**Consultation Response from KC,
Highways Development Management**

2022/93128 2, Bayfield Close, Hade Edge, Holmfirth, HD9 2QX

Alterations to convert part of garage to extend living accommodation and erection of single storey rear extension to replace glazed conservatory

Date Responded: 19/10/2022

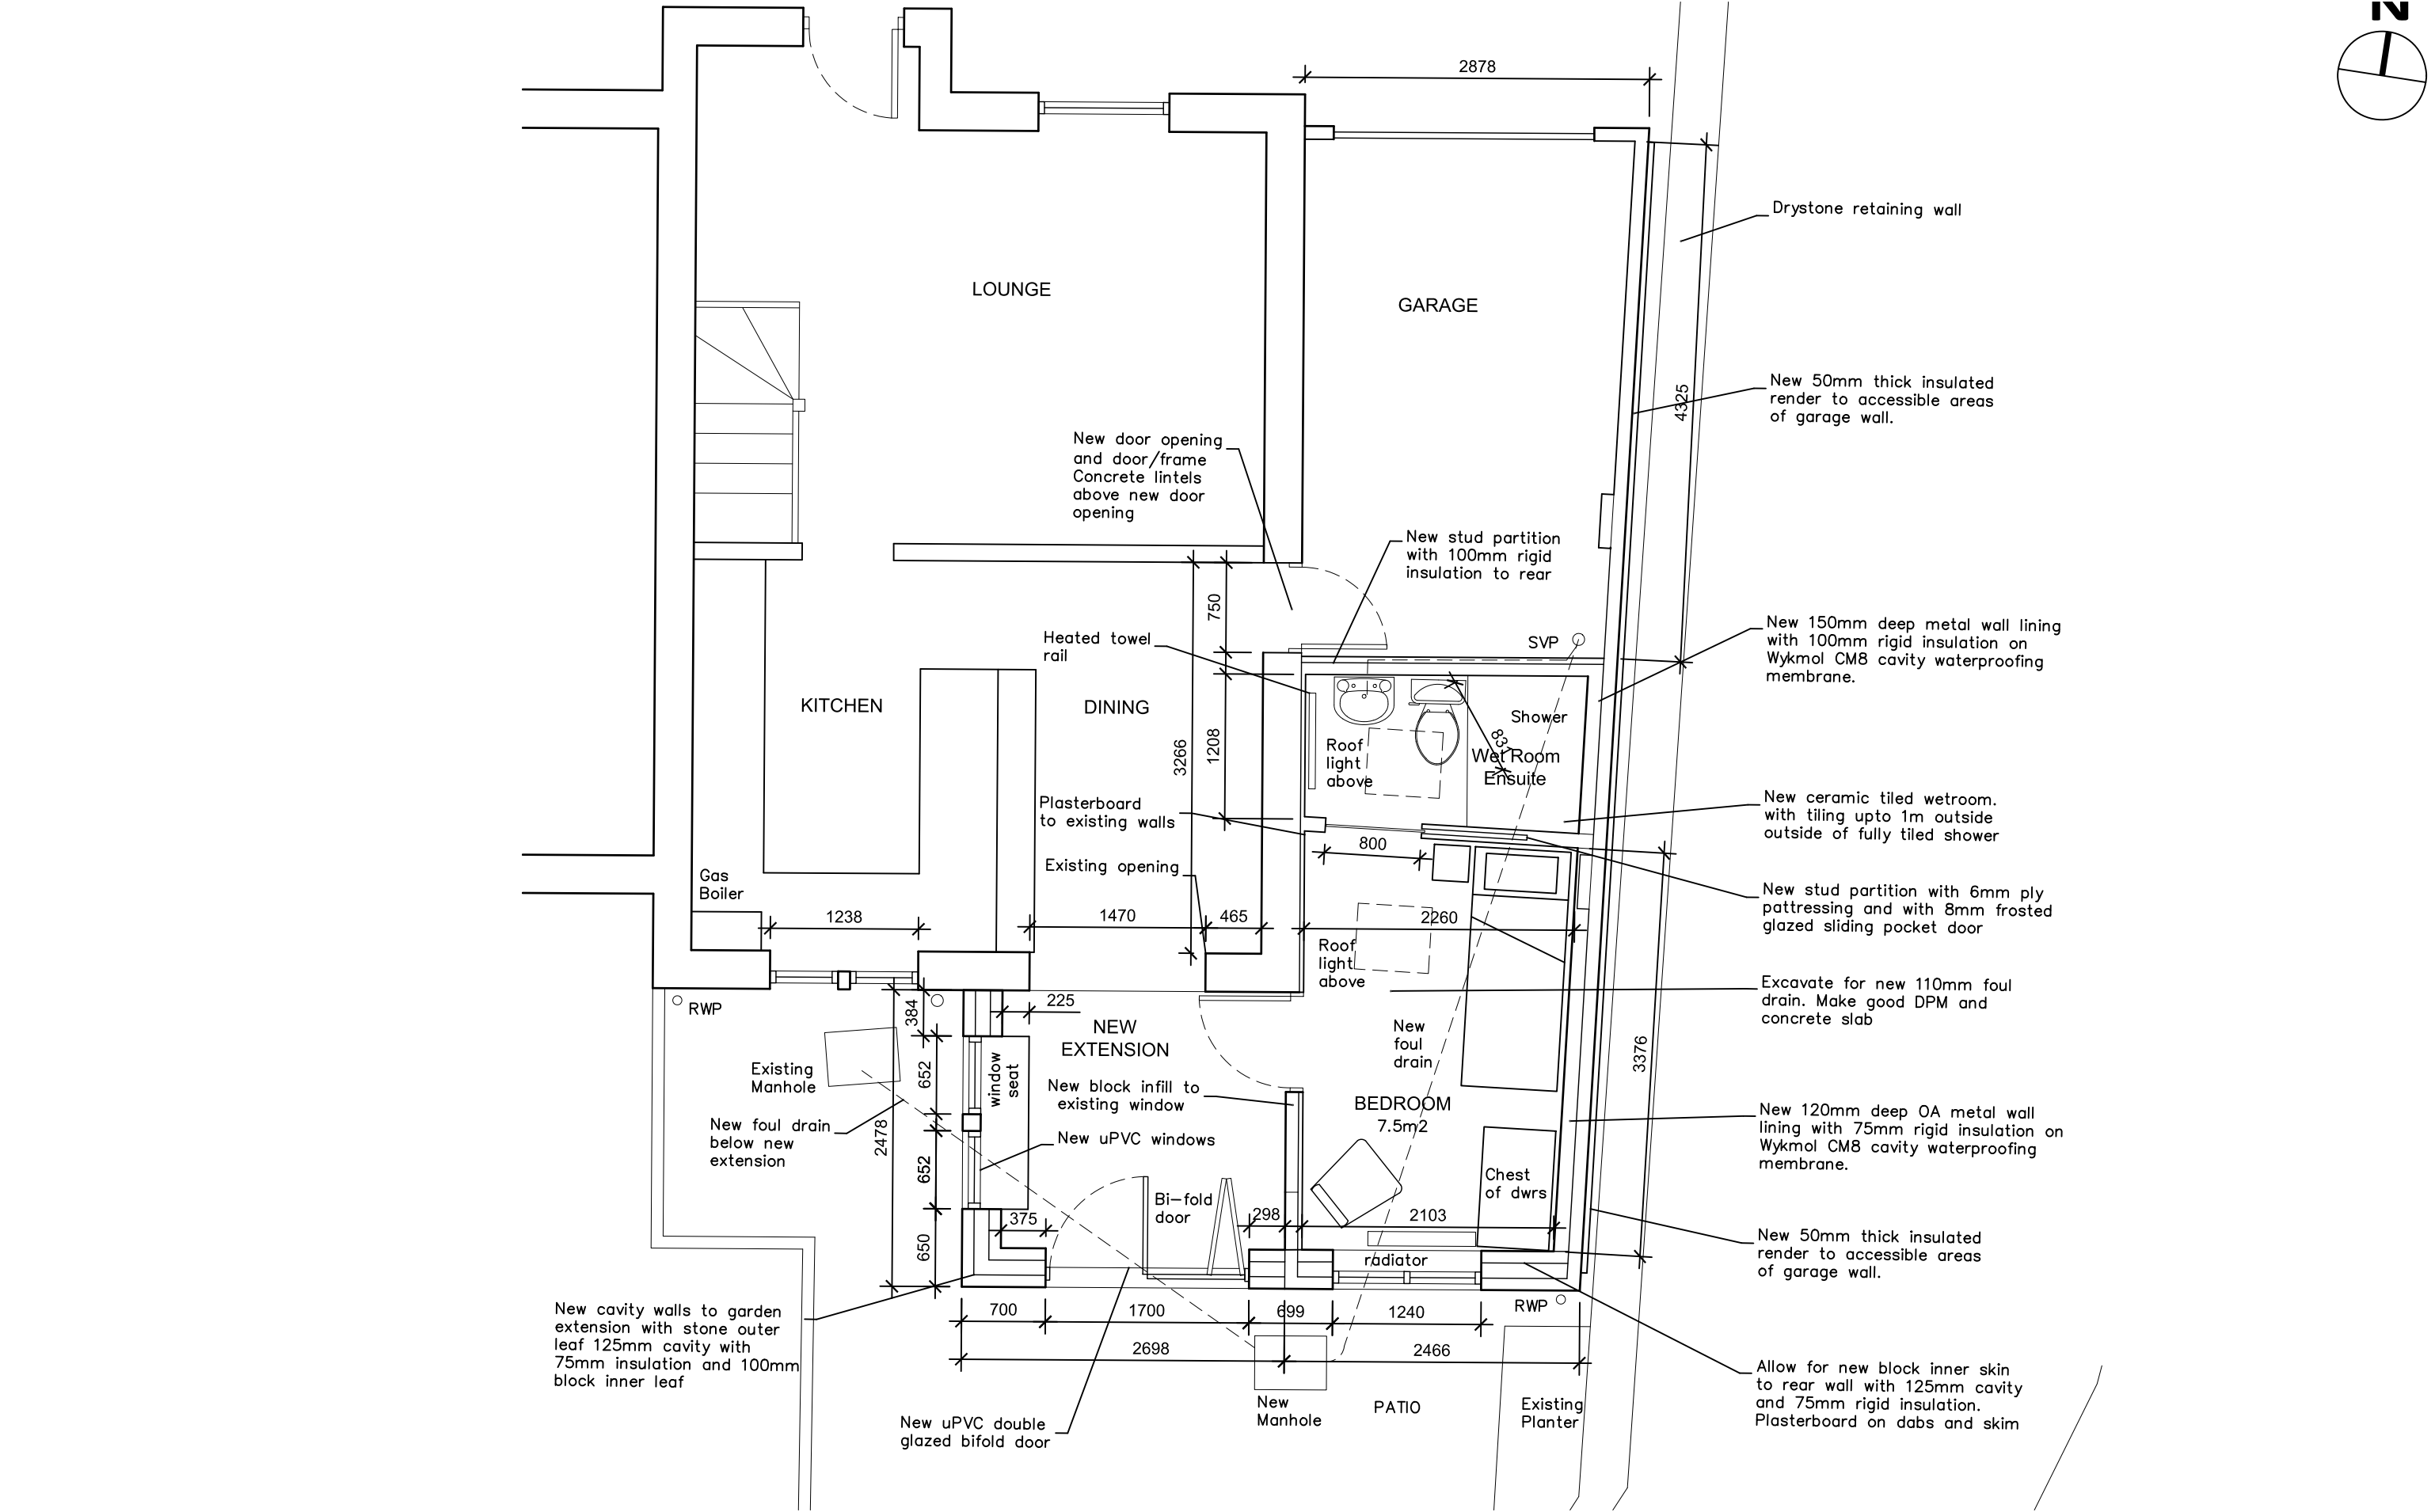
A revised layout showing the number and location of both the existing and the proposed parking spaces needs to be provided

I am assuming that the existing 3-bedroom property has two parking spaces, including the garage as this appears to be typical for the estate. However, no details of the existing parking provision have been provided.

The proposals show an additional bedroom being provided which would increase the size of the property to a 4-bedroom dwelling and a reduction in the size of the garage making it too small to accommodate a vehicle.

Going on my assumption that the existing property has 2 parking spaces, then the proposals will reduce this provision to only one parking space whilst increasing the size of the property from a 3-bedroom to a 4-bedroom

Local guidance suggests that for a 3-bedroom property a minimum of 2 parking spaces would be required, whilst for a 4-bedroom property a minimum of 3 parking spaces should be provided.

A revised layout showing the existing car parking spaces needs to be provided together with a proposed layout showing that 3 car parking spaces can be accommodated as part of the proposals.
